Office of  
Environment  
& Heritage

Your reference: SSD-5066  
Our reference: DOC15/184857  
Contact: Richard Bonner, 9995 6917

I refer to your letter received by the Office of Environment and Heritage (OEH) on 27 May 2015 requesting comments on the Sydney Intermodal Terminal Alliance (SIMTA) State Significant Development Application (SSD-6766) and Environmental Impact Statement (EIS) for the Stage 1 – Intermodal Terminal and Rail Connection located on the eastern side of Moorebank Avenue, Moorebank.

## Attachment 1: OEH comments on the EIS for SIMTA Stage 1 – Intermodal Terminal and Rail Connection Development Application (SSD 6766)

Figure 3 Location of Aboriginal heritage sites associated with the project

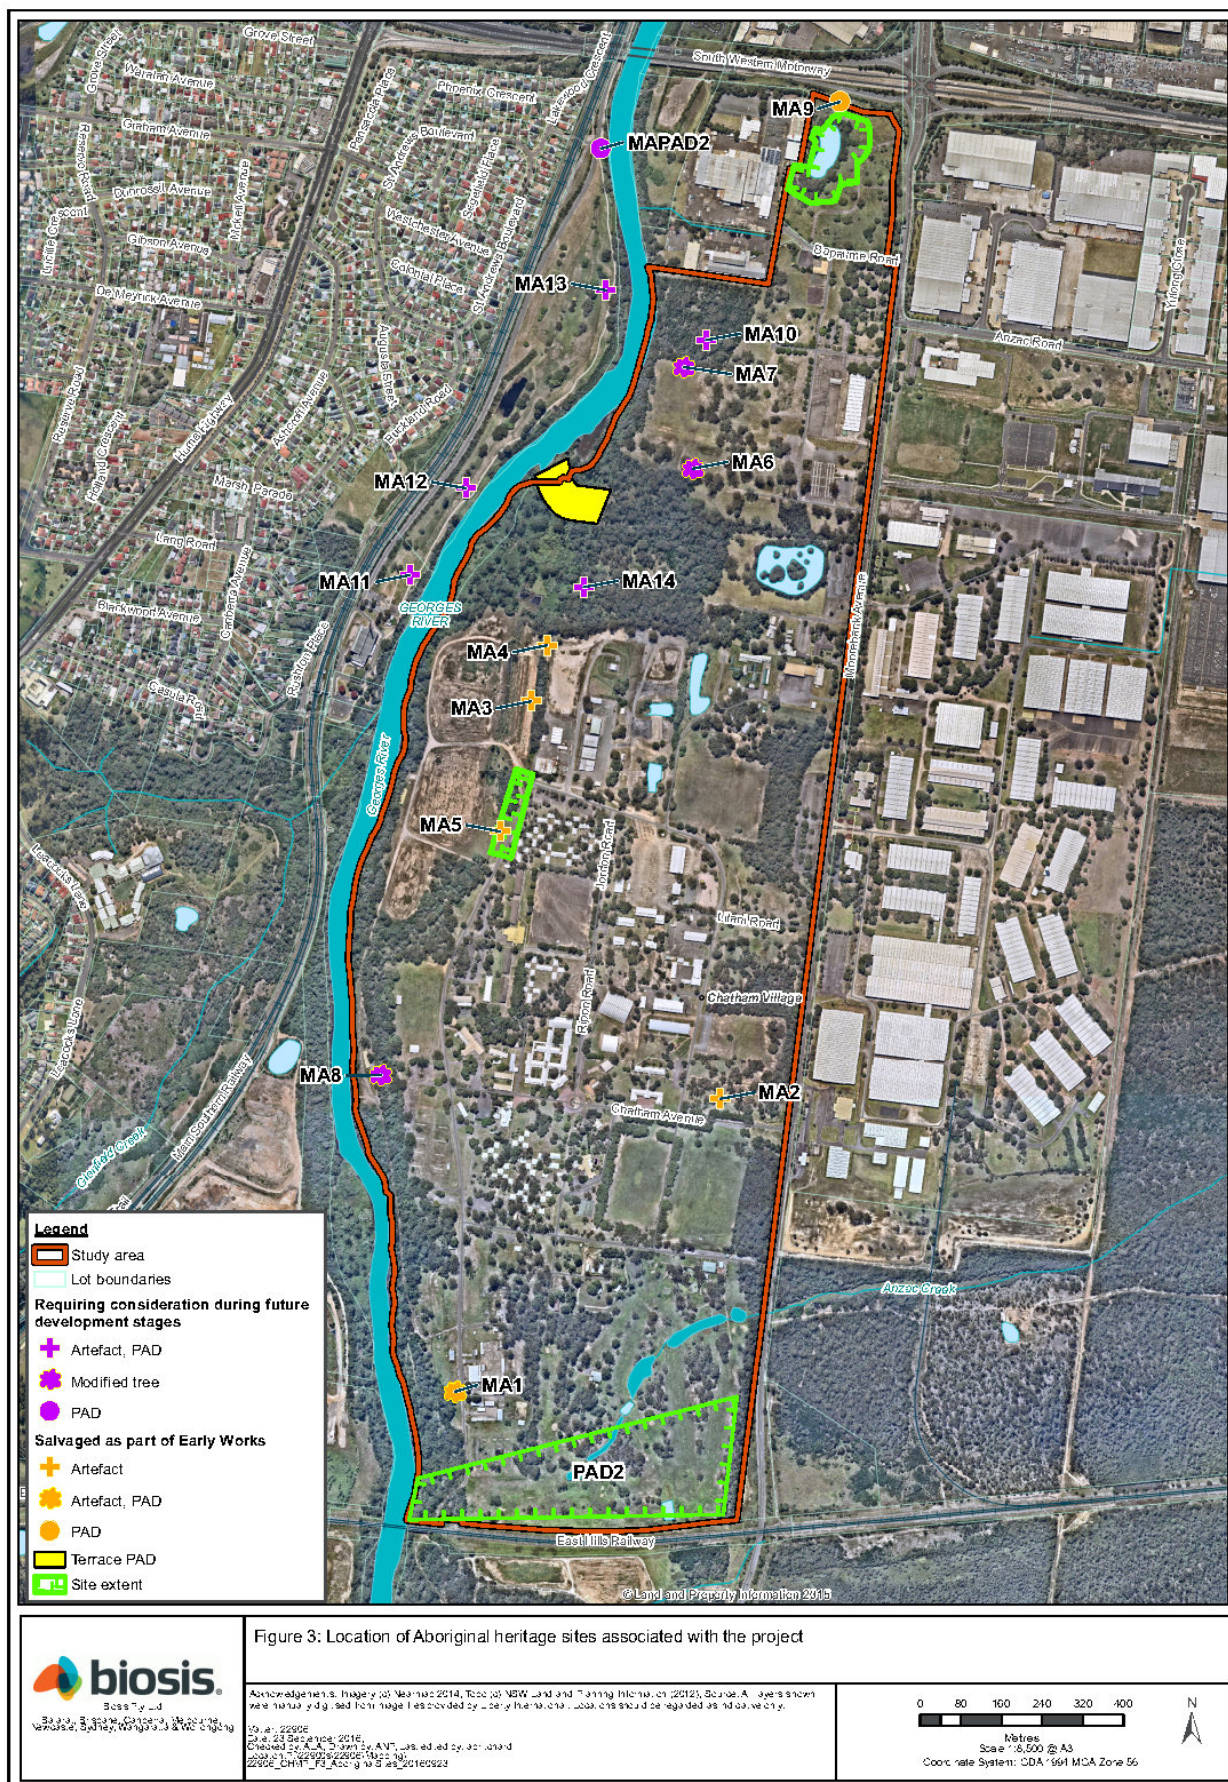
- OEH recommends that a final decision regarding the long term management of Aboriginal objects be made as soon as possible. If objects are to be reburied on site, the location will need to be registered on the AHIMS and any subsequent impact or harm may require an AHIP. If objects are to be reburied on site, OEH considers that long term protection of the location should be determined and secured.

- OEH notes at dot point 4 of section 15.4 (Mitigation Measures) of the EIS: *'The Proposal is likely to impact one Aboriginal site, MA14 (artefact scatter and deposit) on the eastern bank of Georges River. If impacted mitigation measures included in Section 9.6 of the draft Aboriginal Heritage Impact Assessment (AHMS, 2015) should be implemented. These include open area salvage excavation of up to 100 m<sup>2</sup> in the vicinity of test pit #3'.* Apart from the reference error to section 9.6 (rather the correct section 8.6) of the *draft Aboriginal Heritage Impact Assessment (AHIA)*, OEH recommends this statement be amended to specify that the mitigation measures be implemented *prior* to any impacts occurring to site MA14 through development activities. This accords with dot point 6 of Section 8.7 (Recommendations) of the AHIA: *'The Stage 1 Proposal is likely to impact one Aboriginal site, MA14 (artefact scatter and deposit) on the eastern bank of Georges River. Due to the significance of this site, additional mitigation measures prior to development is recommended and outlined in **Section 9.6** [sic] of this report...'*
